SITE PLAN

YALE BUSINESS CENTER
1200 YALE BLVD SE
ALBUQUERQUE, NM

SP-1	11/30/2017
------	------------

1 SITE PLAN  
SP-1 SCALE: 1" = 10'

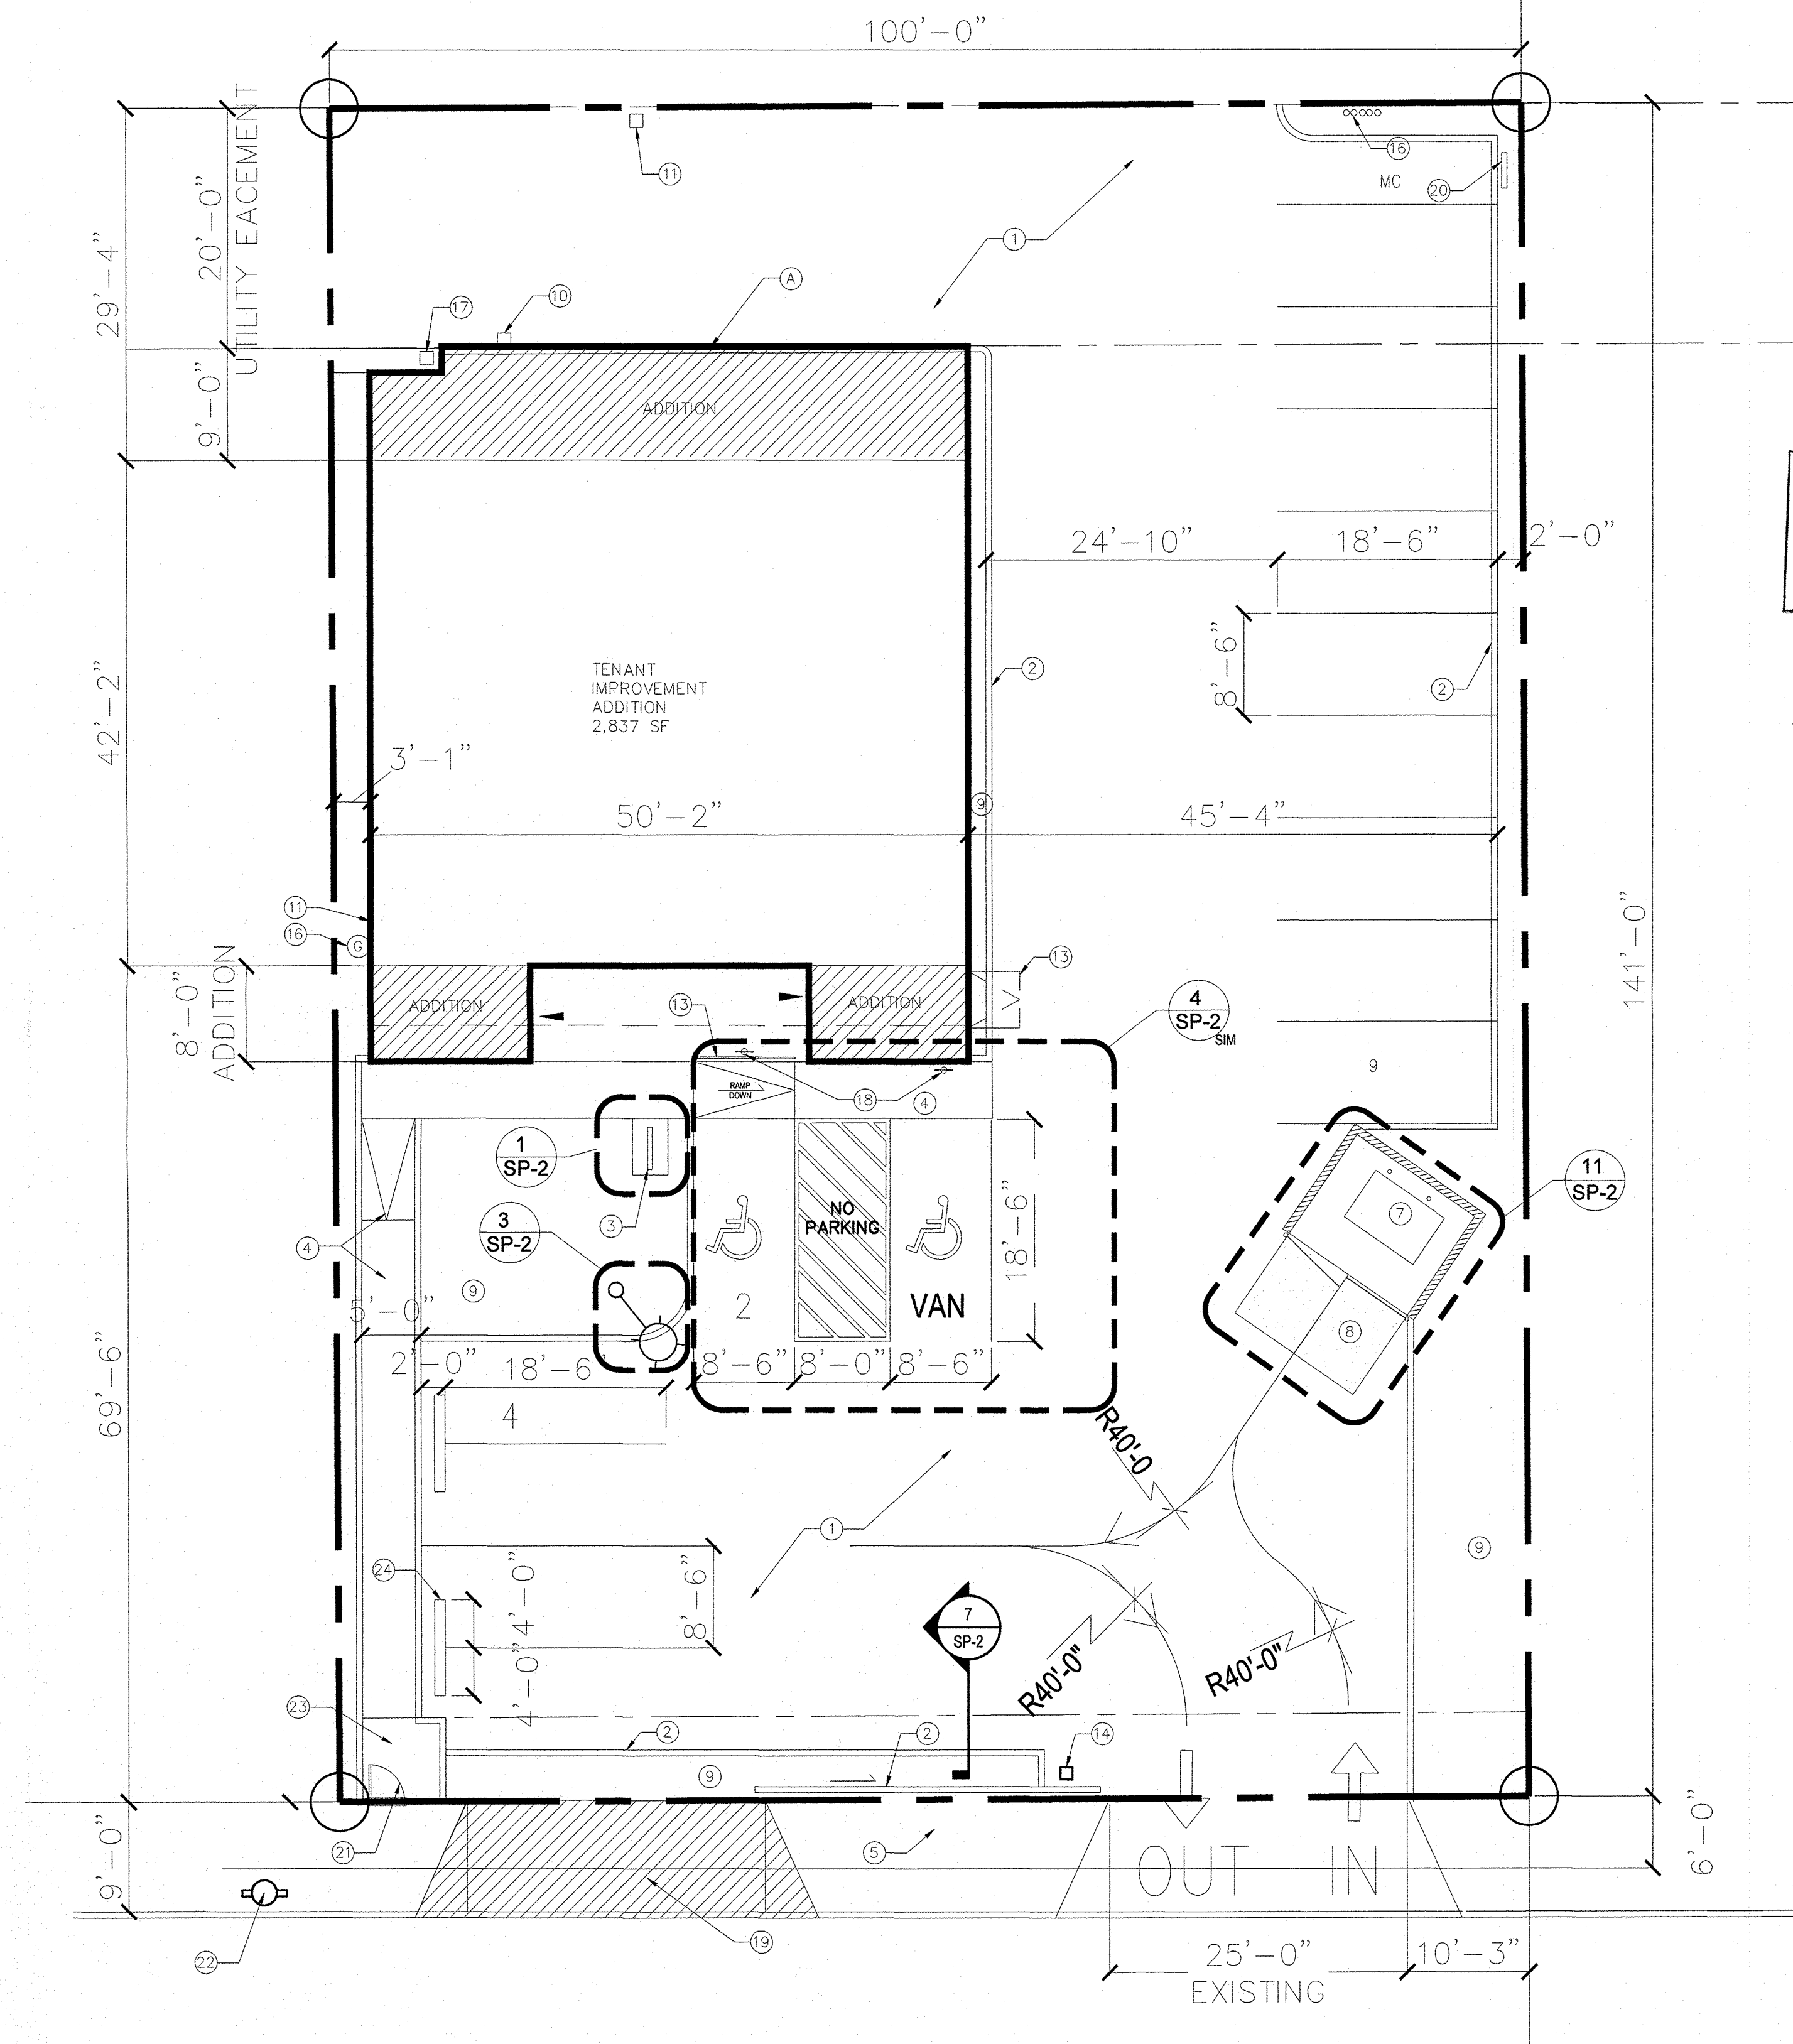
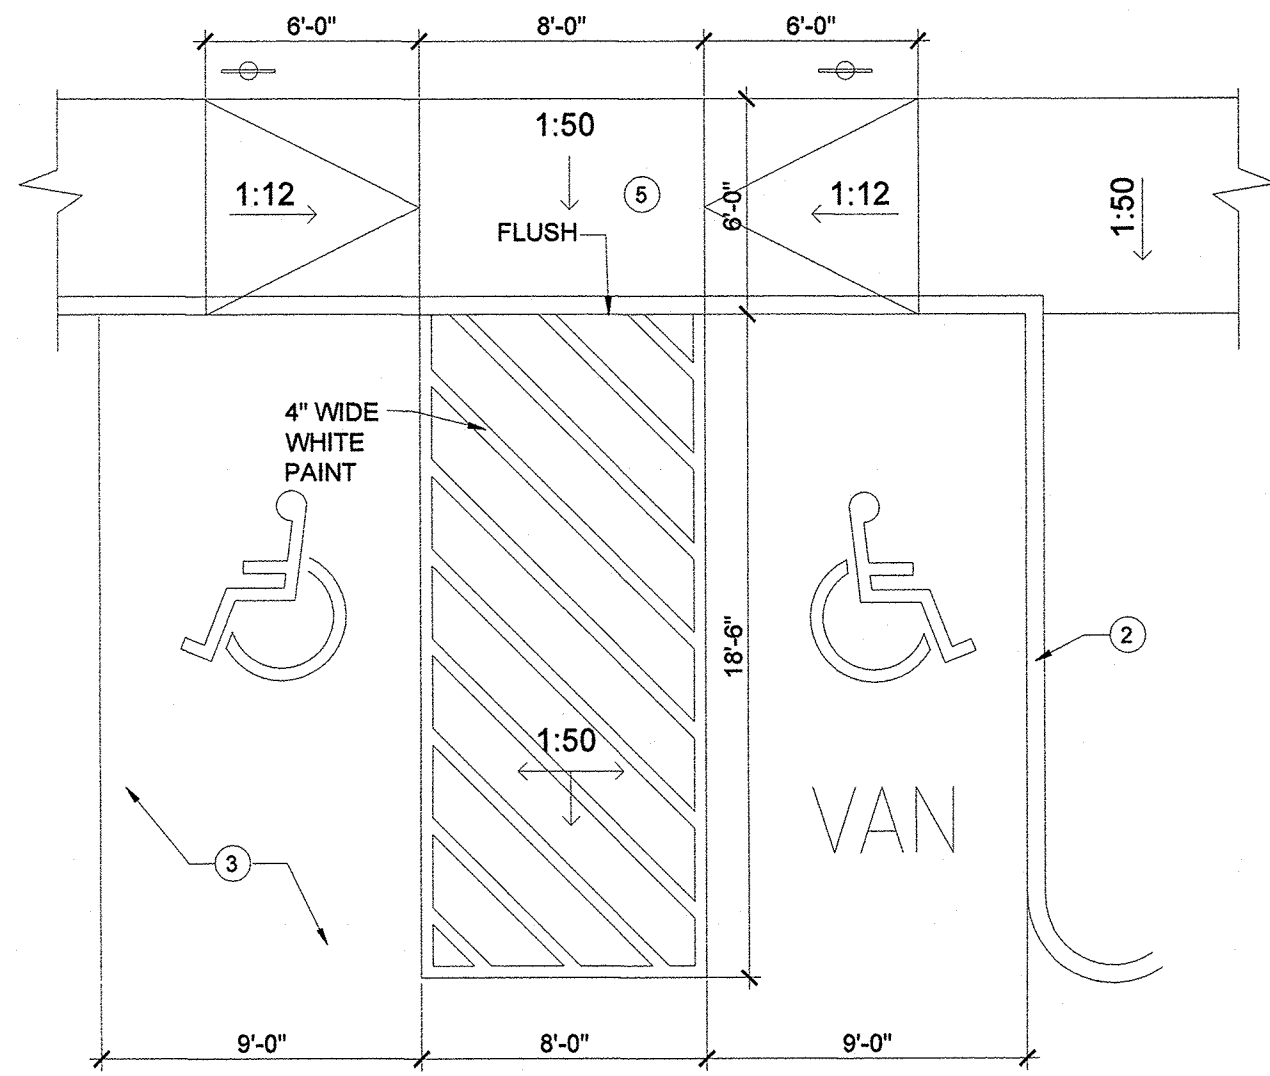
item #1 old driveway removed

item #2 motorcycle sign added

item #3 Bike rack added

Deleted from plan, not done.
All other items done except for curbs as noted.
stripping placed ~~as~~ instead of curbs

stripping done instead of curb
